Recommendation Report for Planning Permission for Works or Extension to a Dwelling

REF NO: AW/59/26/HH

LOCATION: 13 Grosvenor Gardens
 Aldwick
 PO21 3EY

PROPOSAL: Single storey rear extension with skylight.

Mr.Shane Anderson
13 Grosvenor Gardens, Bognor Regis,
West Sussex PO21 3EY
PROPOSED FLOORPLANS 01
A3 PAPER
Date: Dec. 2025 Scale 1:100 Dwg.no. PR.FP.01

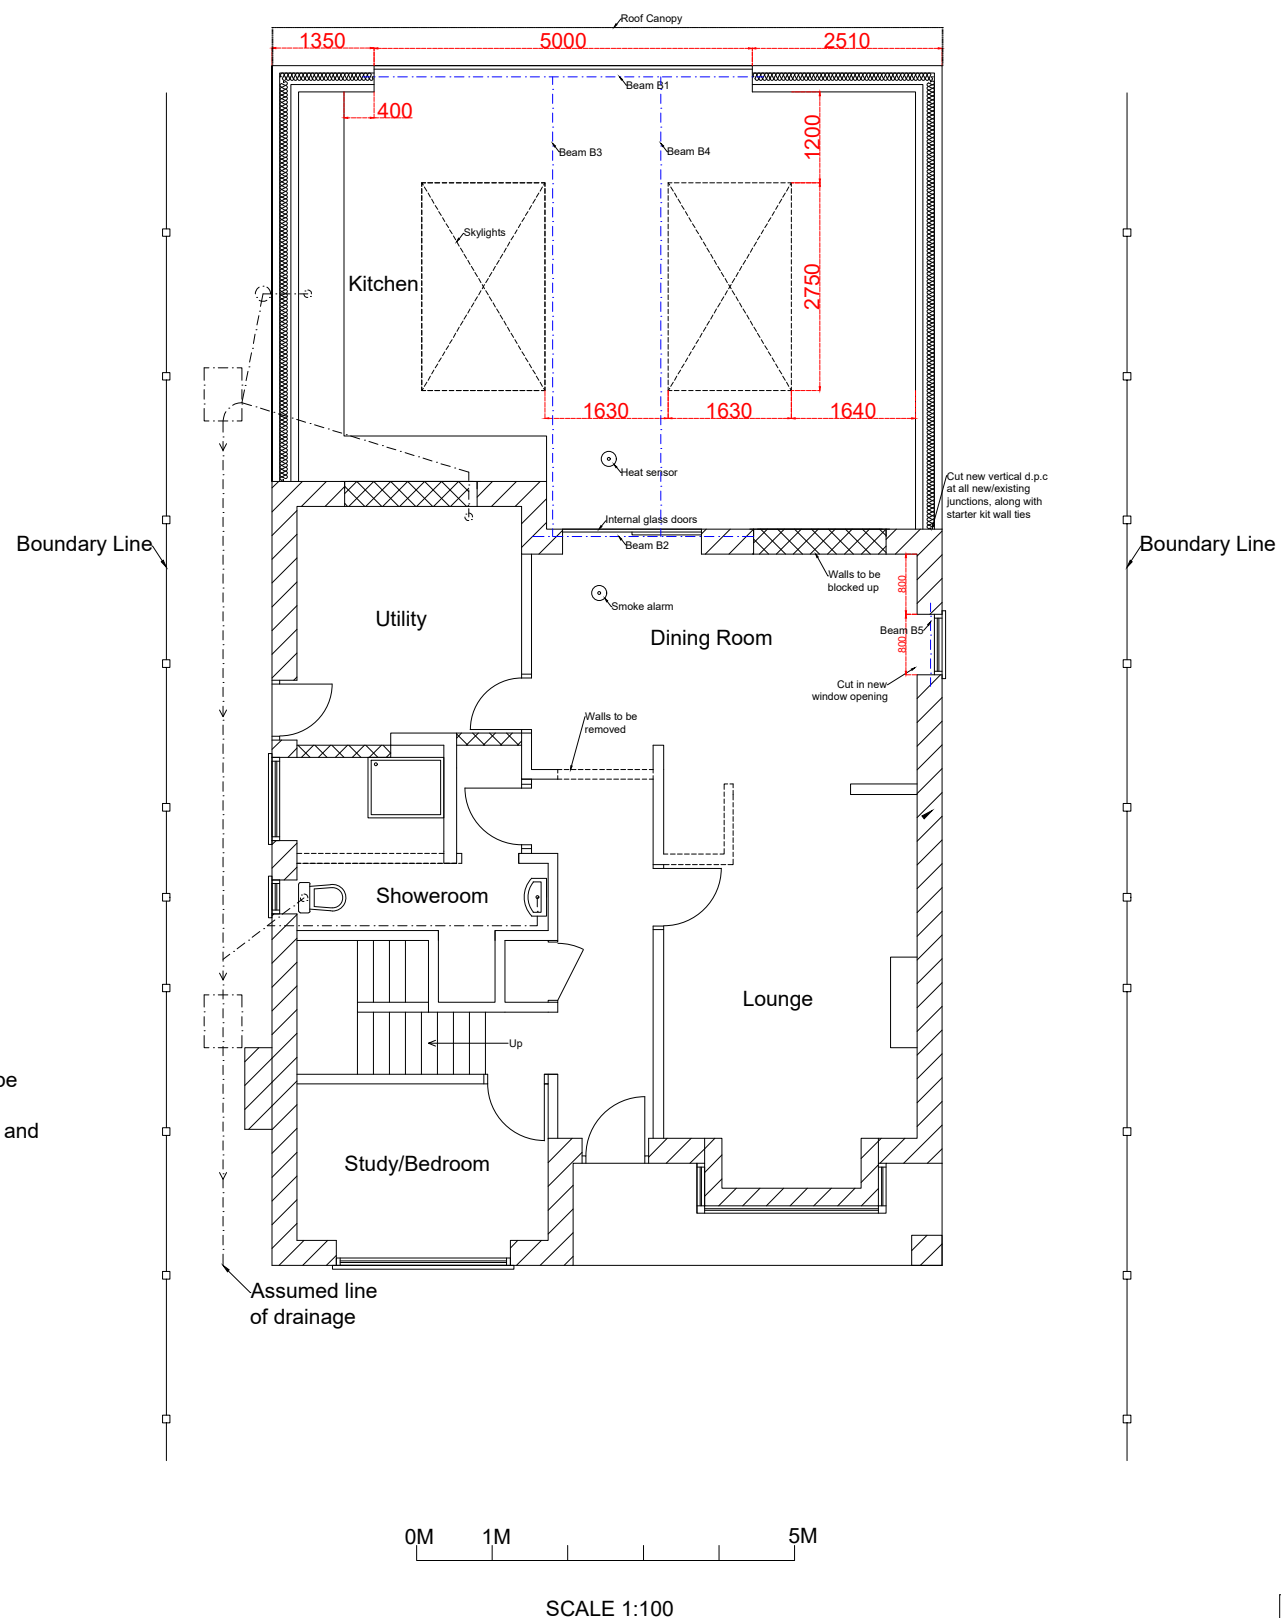
The proposed fenestration would include large fully glazed sliding door to the rear (south) elevation, providing access to the private amenity space, alongside two centrally positioned rooflights within the flat roof section. Additionally, a new single-pane window is proposed within the side (west) elevation of the existing dwelling to serve the dining room.

Mr.Shane Anderson
13 Grosvenor Gardens, Bognor Regis,
West Sussex PO21 3EY
PROPOSED ELEVATIONS 01
A3 PAPER
Date: Dec. 2025 Scale 1:50 Dwg.no. PR.E.01

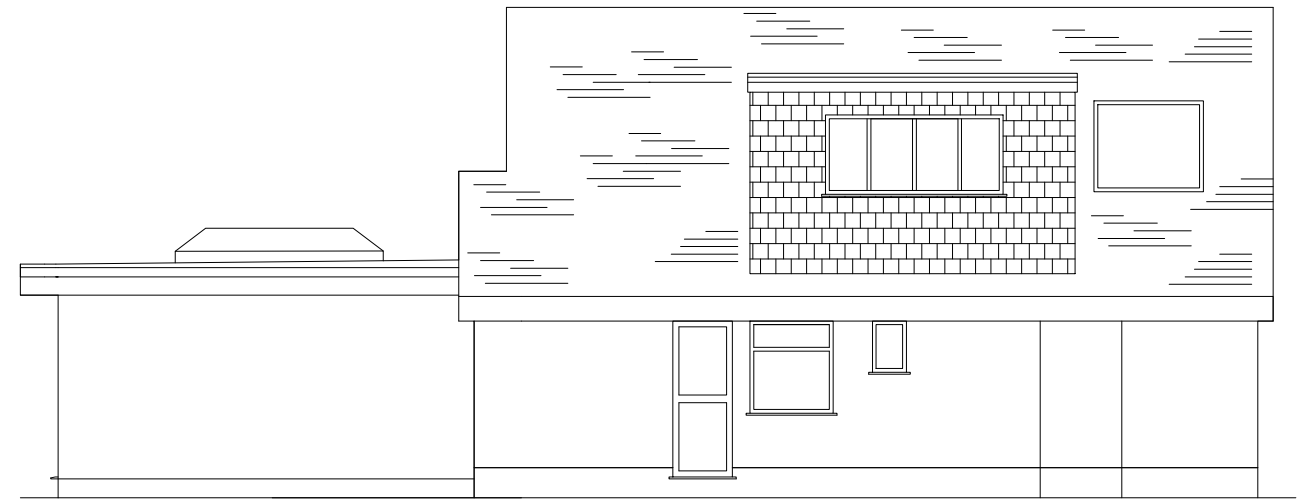
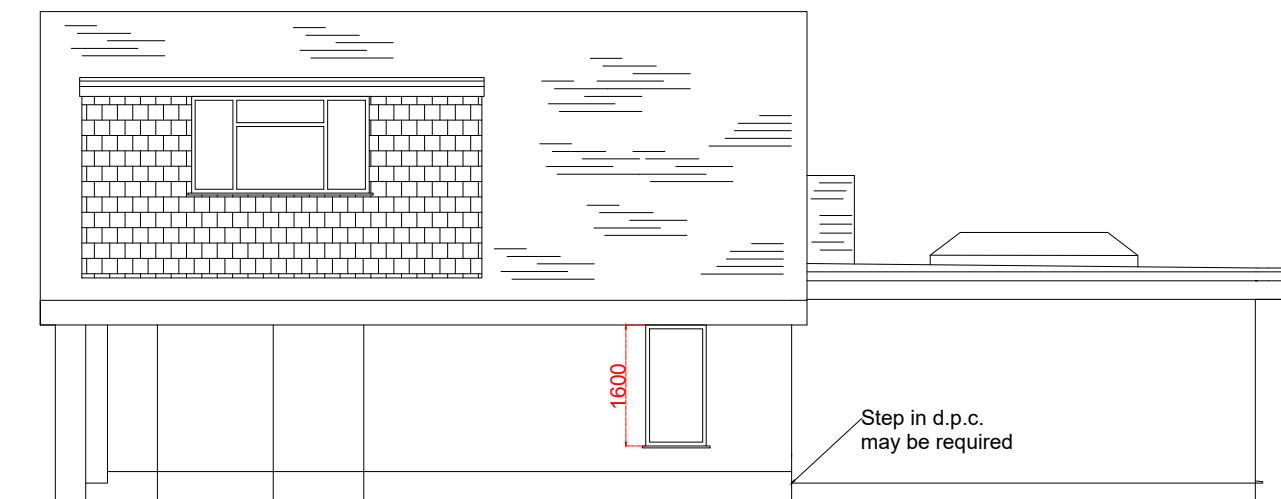
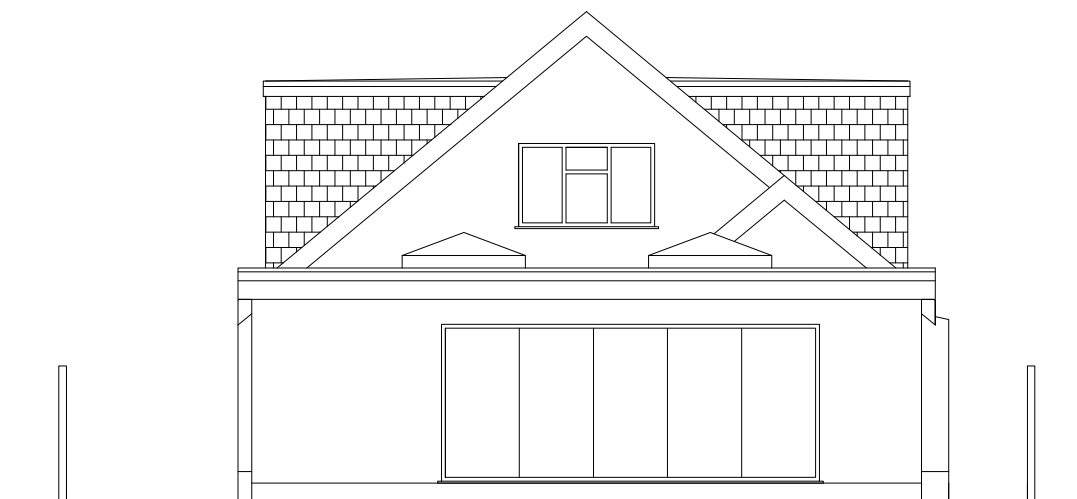
The proposed extension would extend across the full width of the dwelling, partially replacing the existing conservatory. It would project approximately 5.4m in depth, and would measure approximately 8.8m in width. It would feature a flat roof form with a maximum height of approximately 3.5m, inclusive of a skylight. The external materials would consist of matching brickwork to the host dwelling, ensuring the development integrates visually with the host dwelling, in accordance with Arun Local Plan (ALP) policy D DM4.

While the extension would not be fully subservient to the host dwelling, which is contrary to the guidance set out within the Arun Design Guide (ADG), it would remain proportionate to the scale of the original bungalow. The depth of the extension would exceed the 3.3m recommended within the ADG for single storey rear extensions. However, given the siting of the extension to the rear within a relatively spacious plot, the deviation from ADG would be acceptable. Furthermore, the development would not be visible from the public realm and would therefore not appear visually intrusive or harmful to the character of the surrounding area. In addition, it is noted that other dwellings within the vicinity have implemented single storey extensions of a similar scale.

A new window is proposed within the western side elevation. This opening would have a similar outlook to the existing first-floor window within this elevation and, due to its ground-floor position, would not introduce any additional or harmful levels of overlooking.

PROPOSED SITE PLAN

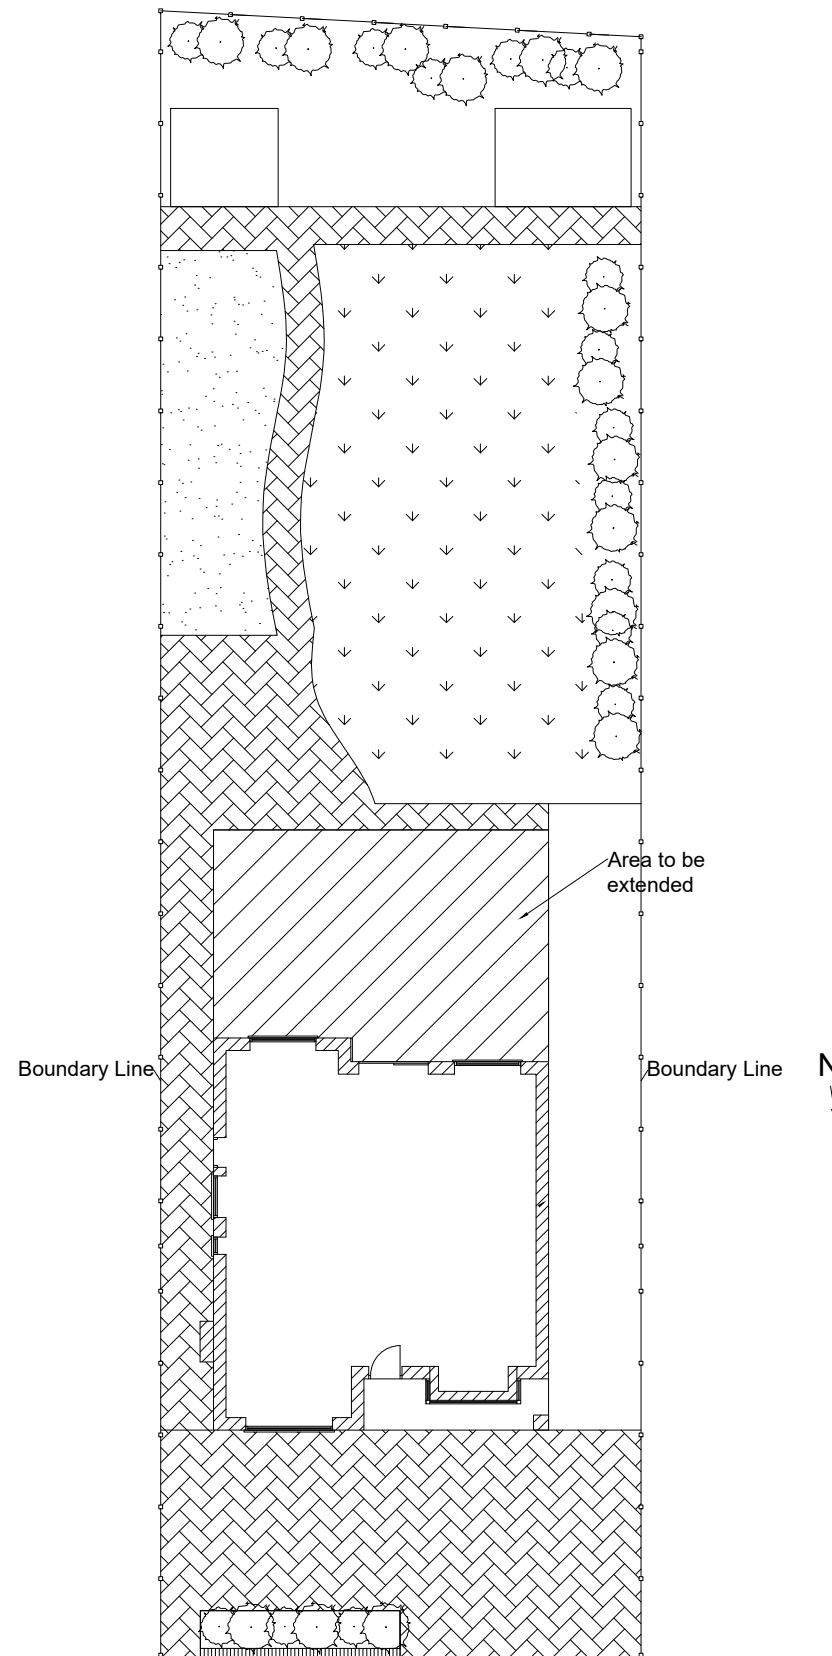
The extension would be set in approximately 2.6m from the western side boundary and 1.4m from the eastern side boundary. Given the limited height and single-storey form of the extension, it would not result any undue overbearing impacts or loss of light to neighbouring occupiers to either the east or west.

The proposed rear fenestration would be in a similar position to the existing windows, with views towards the private rear garden. As such, no additional overlooking or loss of privacy would arise as a result of the development. Furthermore, the proposal would retain approximately 20m of rear garden depth, which significantly exceeds the ADG recommendation of 10.5m. It is also noted that there are no neighbouring properties located directly to the south.
